SUBMISSIONS REPORT

104-116 Regent Street,
Redfern

15 June 2022

DRAWING SERIES
Elevations
DRAWING TITLE
Northern Elevation + Southern
Elevation

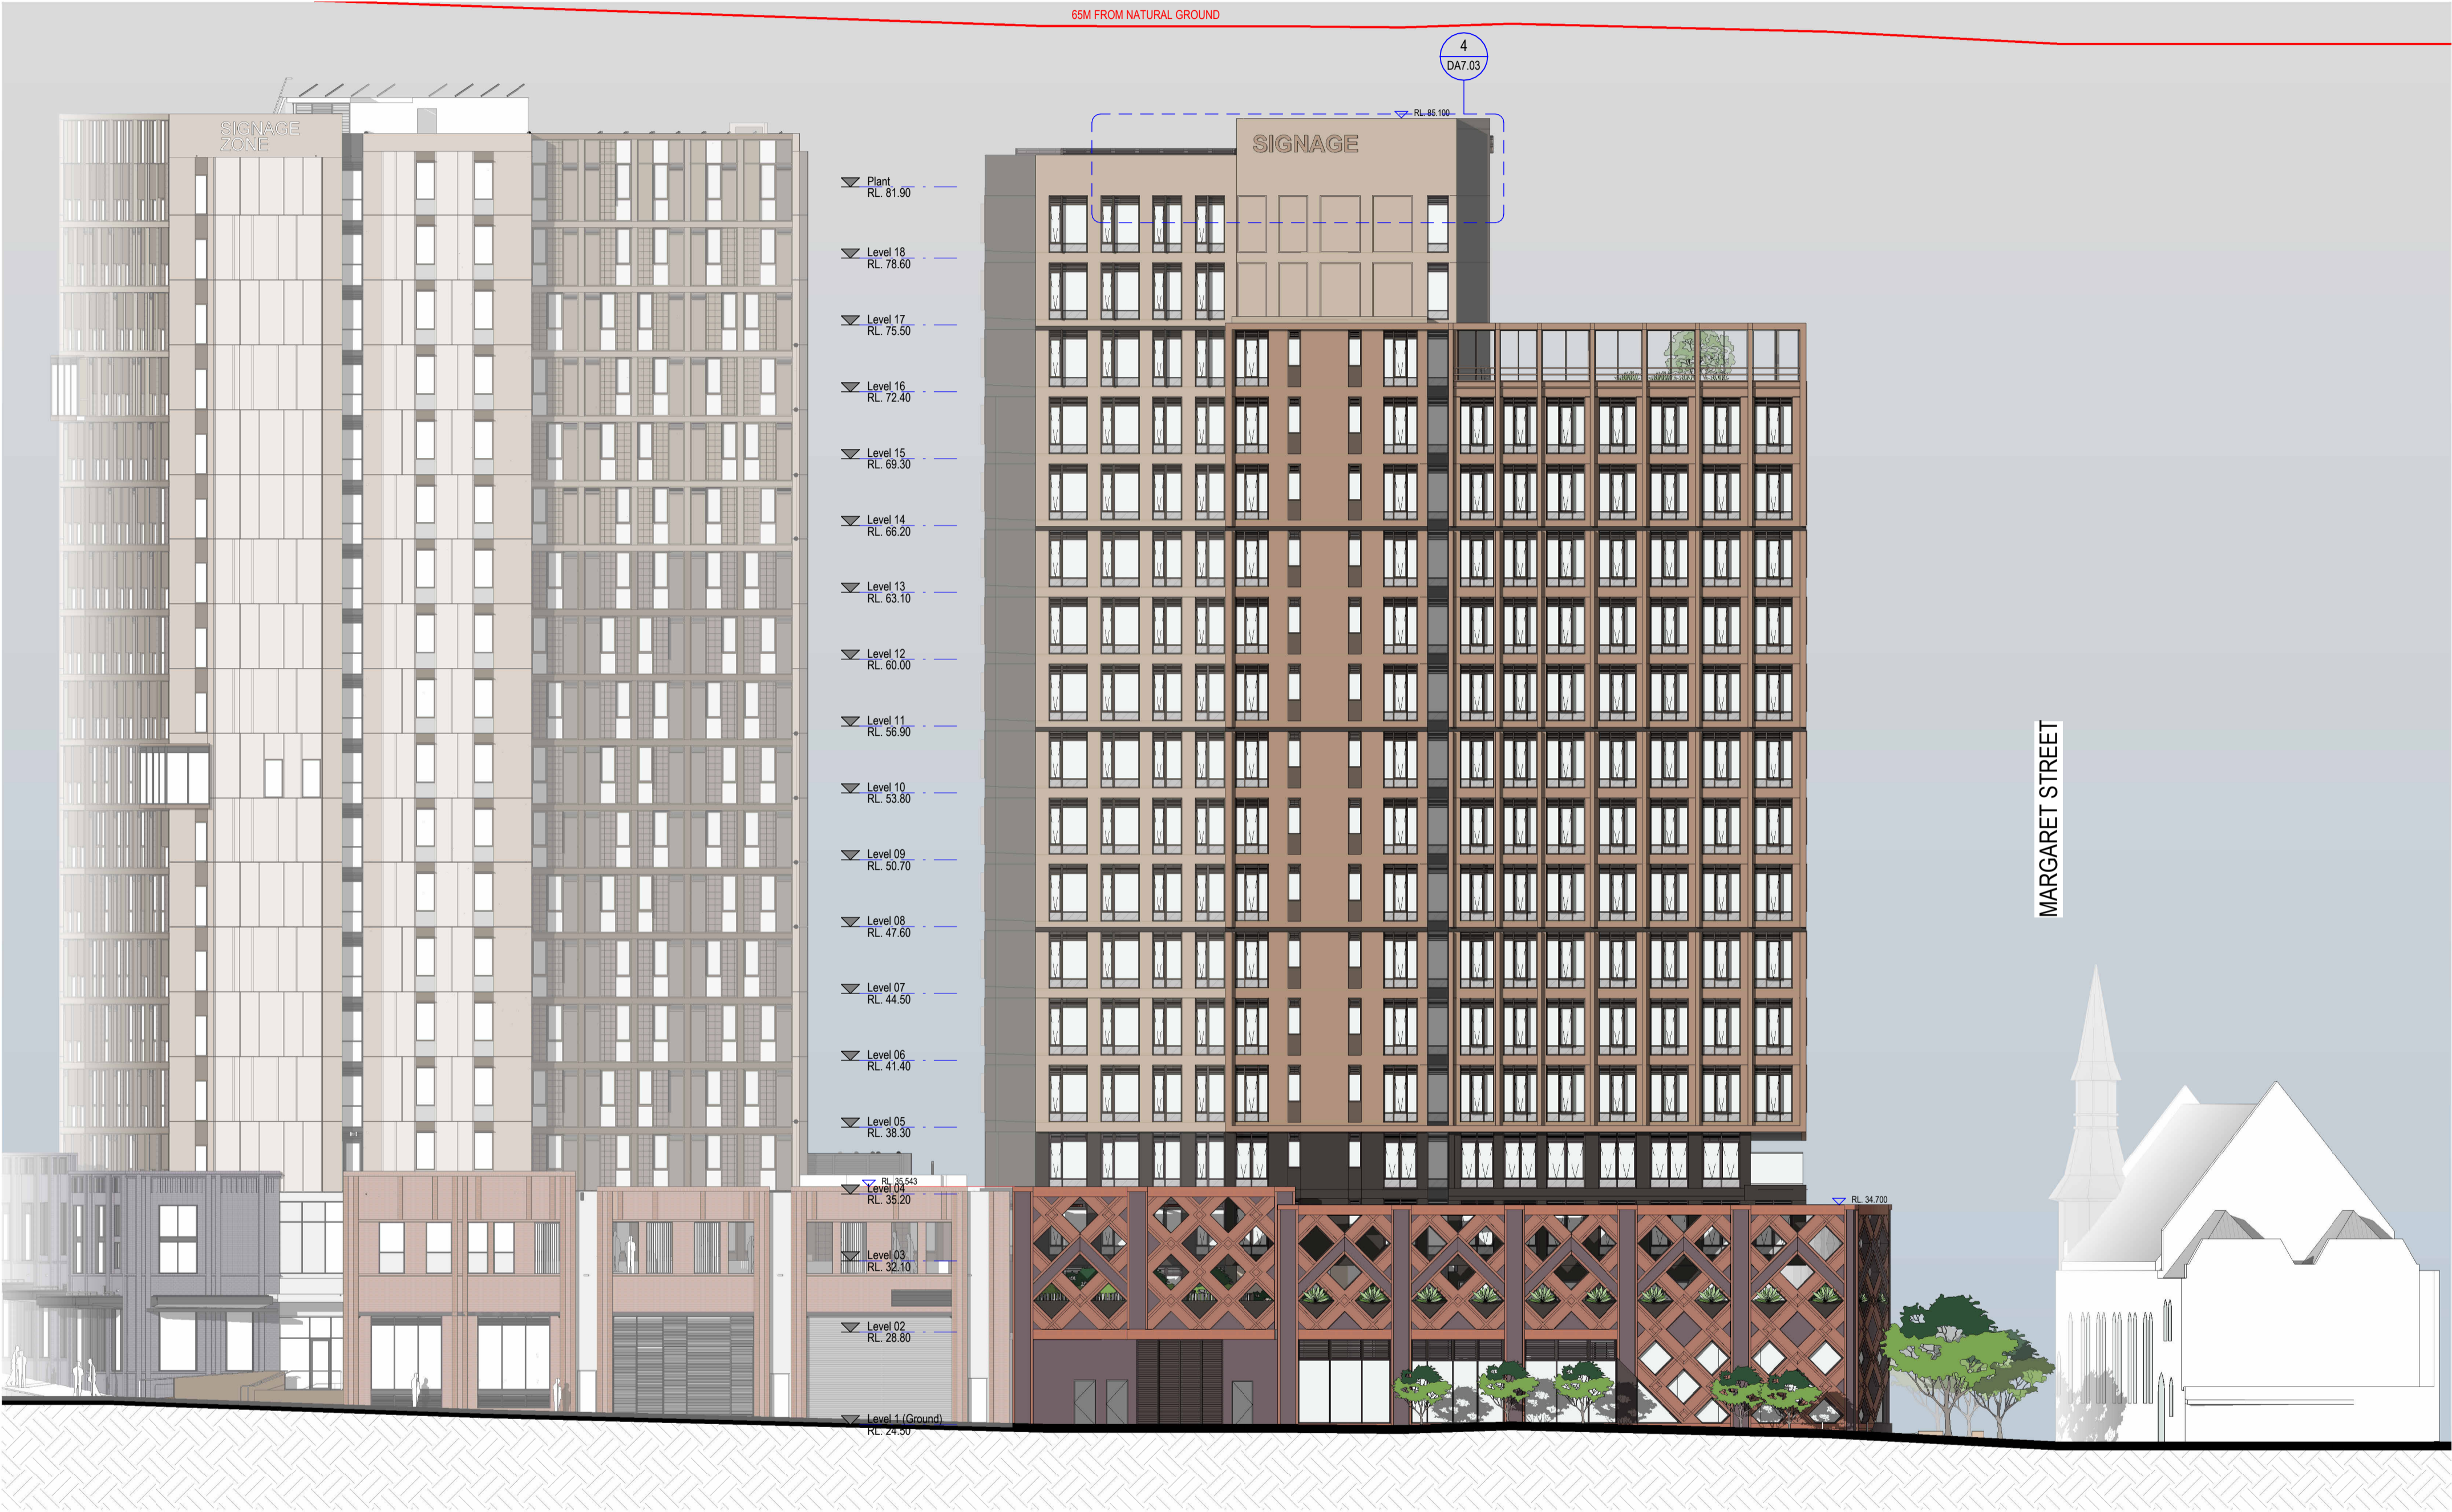
- The Department supports increased setbacks at the southern boundary. The Department's main concern is the 0.3 m setback from 90-102 Regent Street in the north-western corner which is maintained from Levels 5 to 18 of the development. The Department recommends this setback be reconsidered.

- Council raised concerns about the 0.3m tower setback to the northern boundary.

- **Removal of the north western room from Levels 4-18:** The revised design has increased the northern tower setback from 0.3m to 2.65m, increasing the building separation from 8.3m to 10.9m, improving visual privacy and separation.
